376 Riverside Industrial Parkway - Permit #2016-02261

PLEASE NOTE OUR NAME, URL, AND EMAIL HAVE CHANGED!**From:** Ann Machado [mailto:amachado@portlandmaine.gov]**Sent:** Tuesday, August 30, 2016 10:33 AM**To:** Luke Ouellet <luke@ocmaine.com>**Subject:** 376 Riverside Industrial Parkway - Permit #2016-02261

I've completed my initial zoning review for this permit. I need some more information before I sign off.

SHEET C1.1

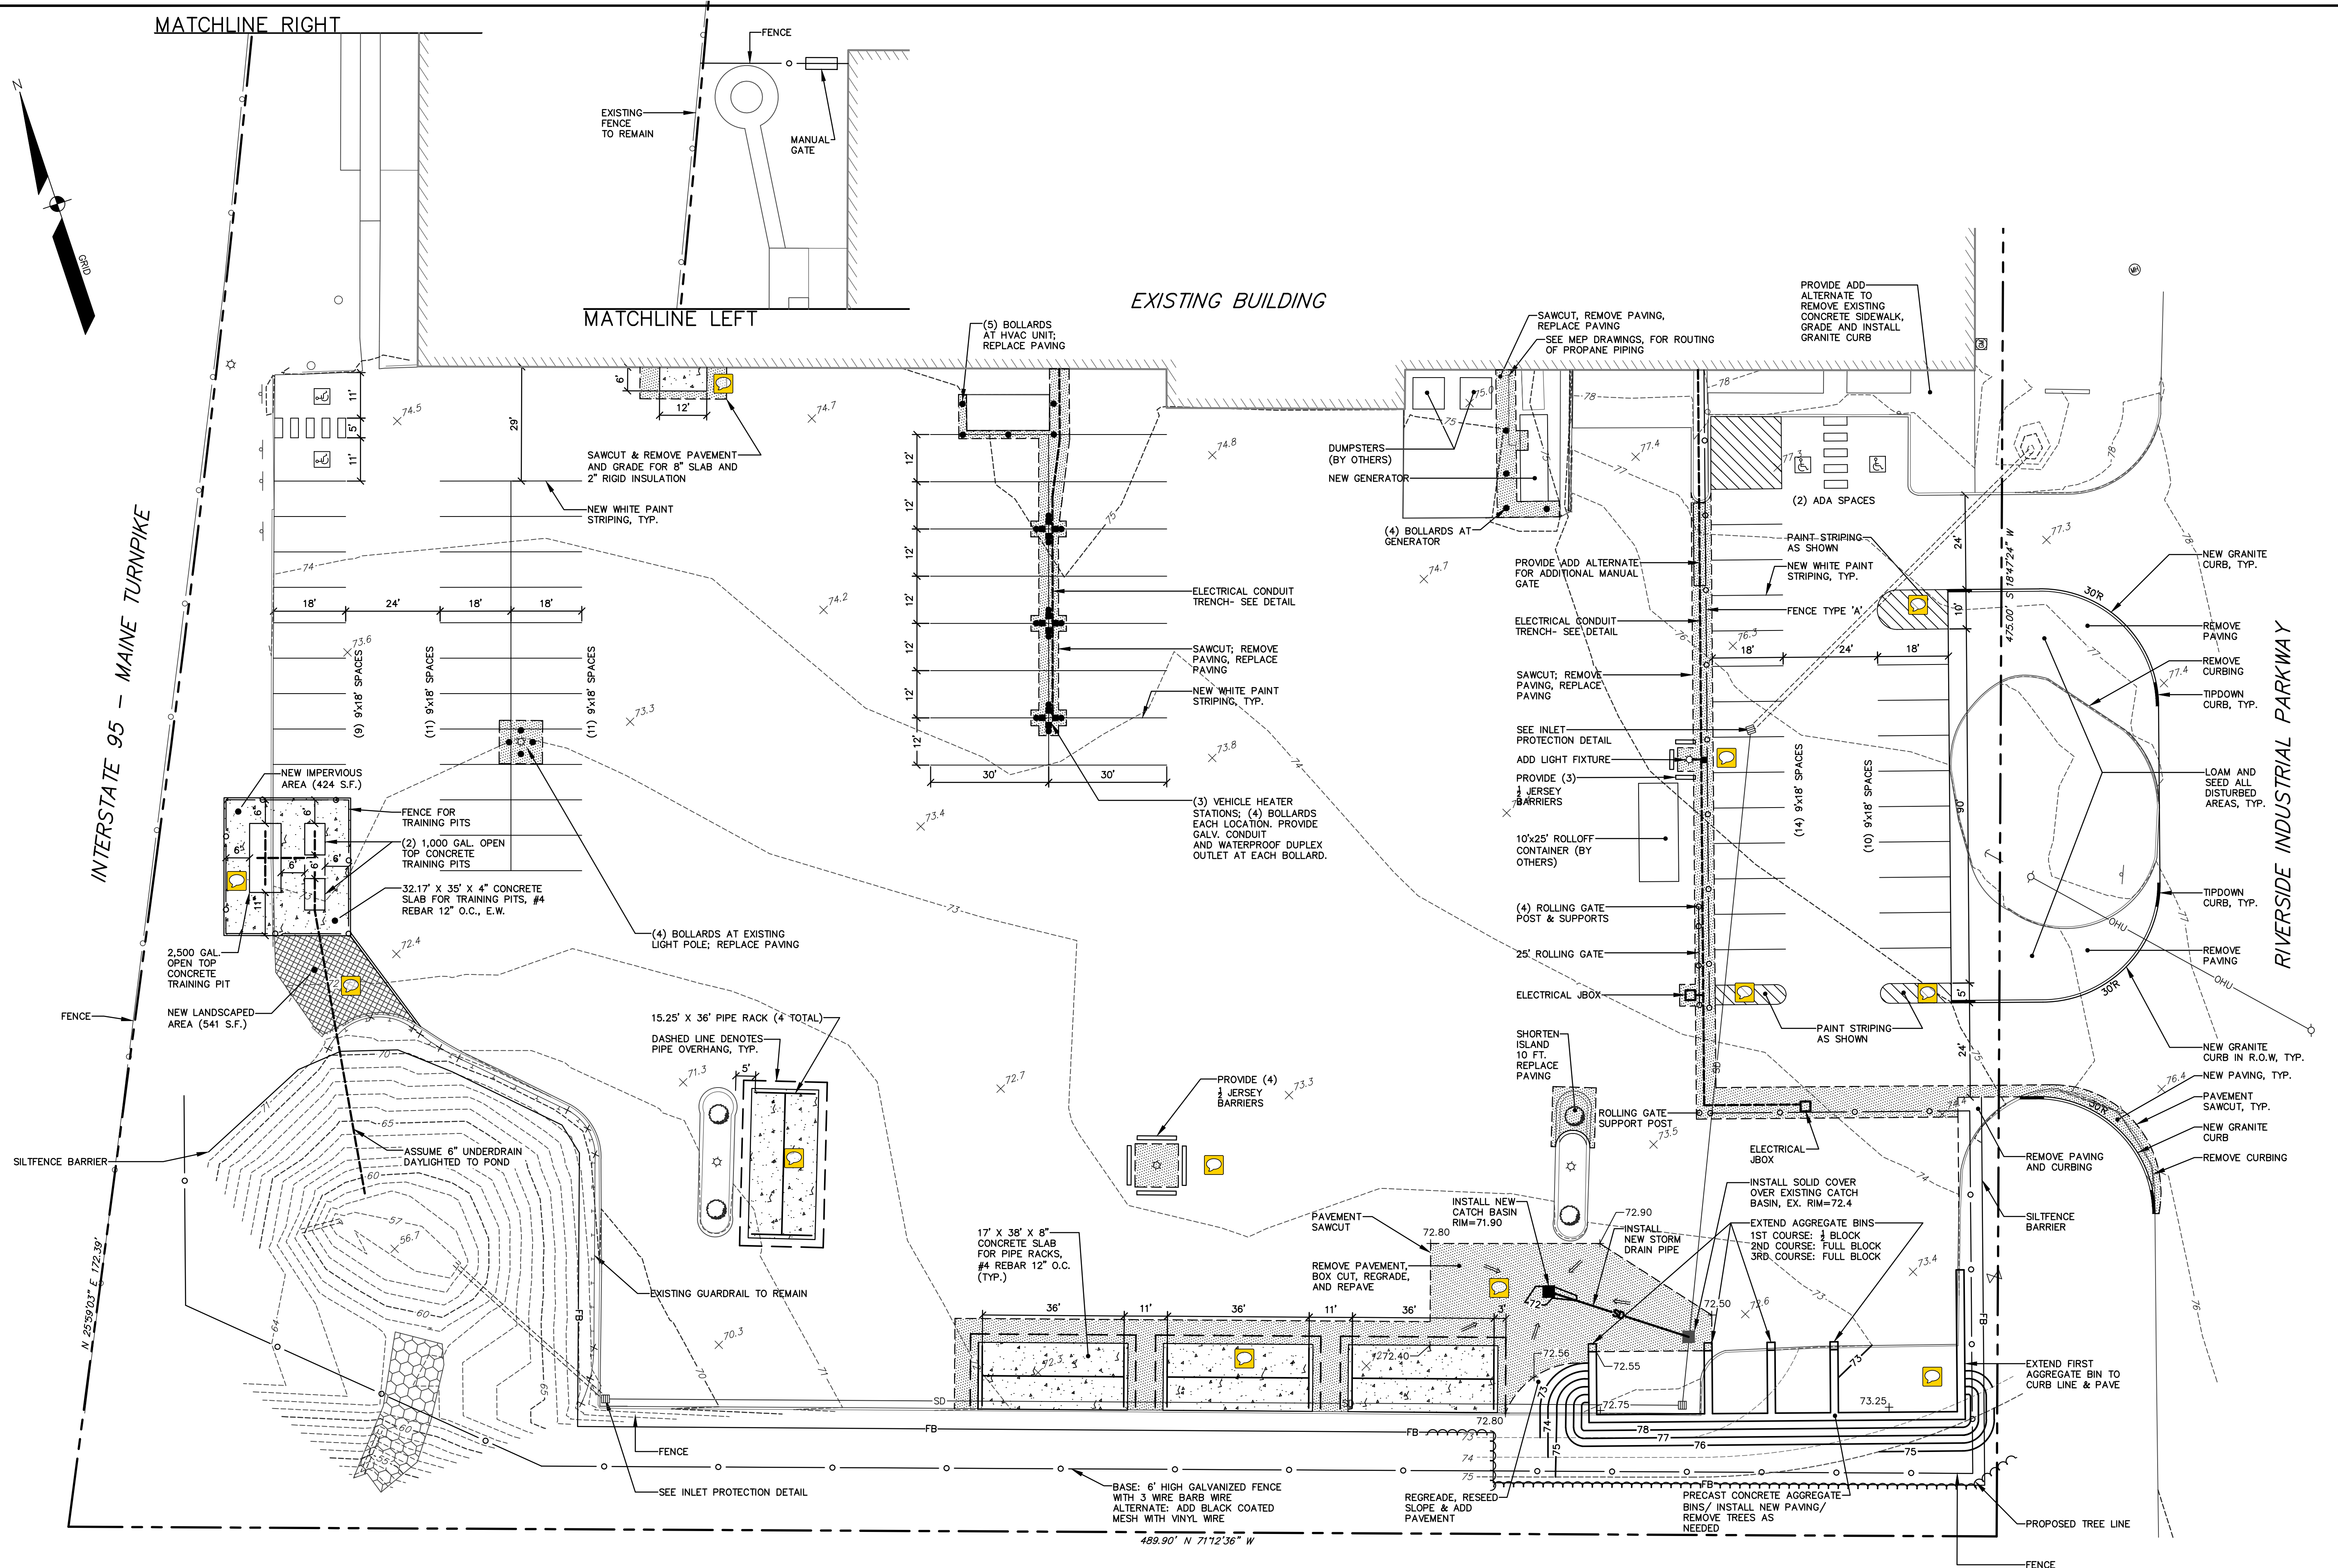
1. The I-M Zone requires a 10' minimum pavement setback from all property lines. I'm scaling the edge of the expanded aggregate bin at 8.22' from the front property line. I'm not sure if that is the edge of the pavement or if the pavement extends beyond that. The pavement must meet the 10' minimum setback.

2. What is the height of the aggregate bin? It needs to be set back from the property line one foot for every foot of height of the bin.

3. I understand that the impervious surface area is being reduced 47 sf. What will the impervious surface percentage be?

[LAO] I will make sure we adhere to the 10' setback even if it means flightly shrinking the last aggregate bin.

[LAO] The bins in that area will be about 5 to 6 feet tall, no higher.

[LAO] Tyler from Sebago to comment. I know we are reducing overall so I'm not sure there is an issue? Just curious,
